PORTLAND MAINE

December 31, 2009

Re: 80 Westminister Avenue – 181 B004 – R-3 – request more information – Permit #09-1434

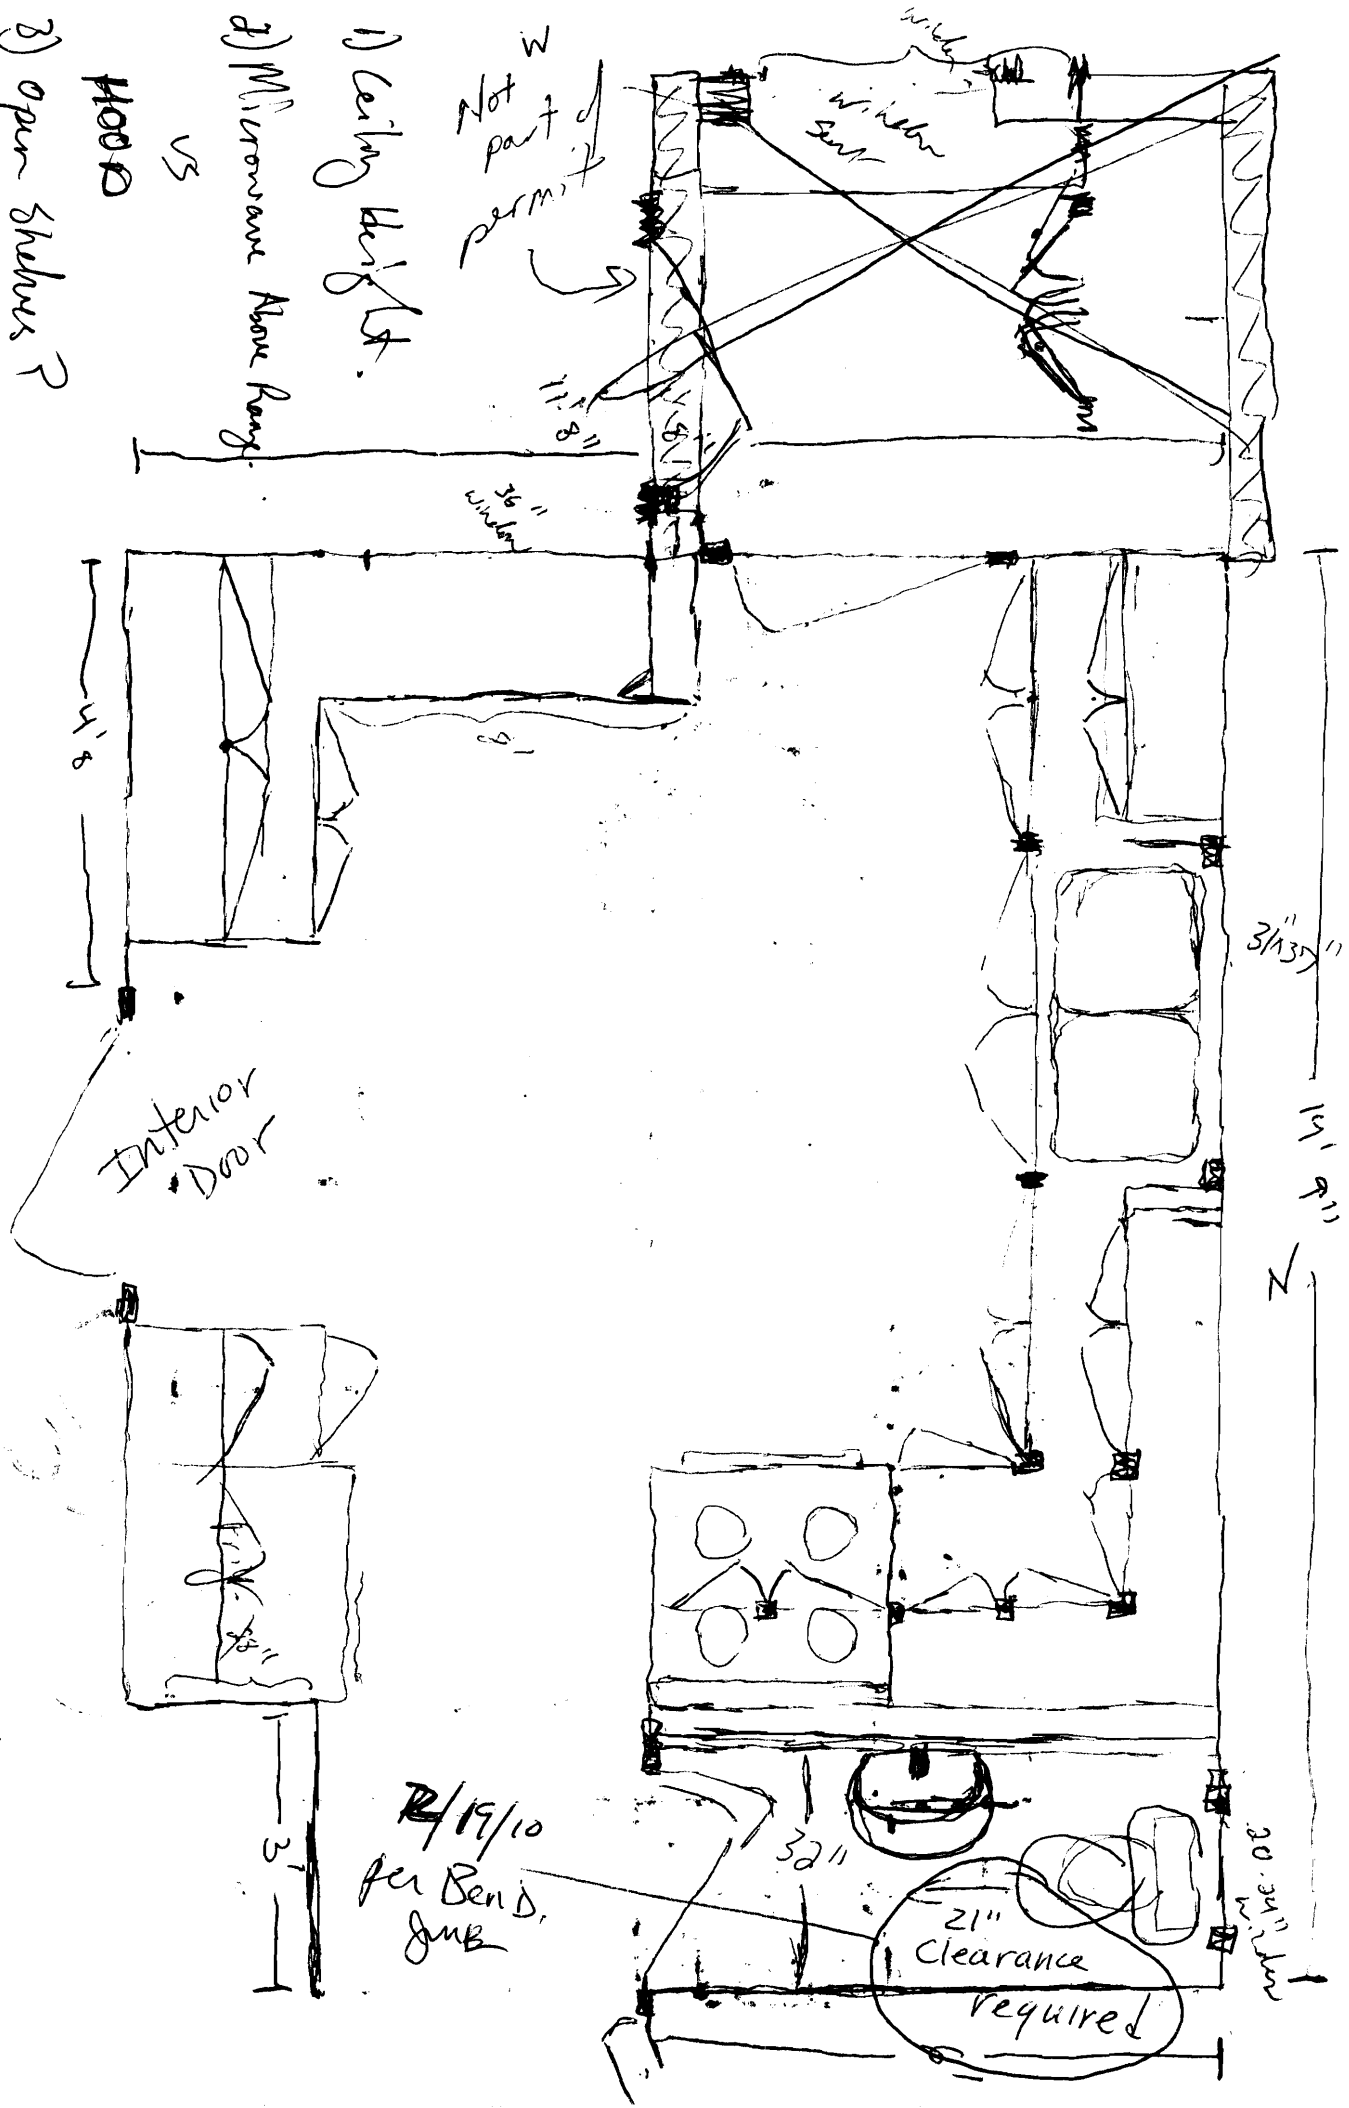
I need to know if the relocated door is within the building or if it leads to the outside. I also need to know if the replacement windows will be the same size as the existing. Finally, you will need to provide more information about the bathroom that you are creating.
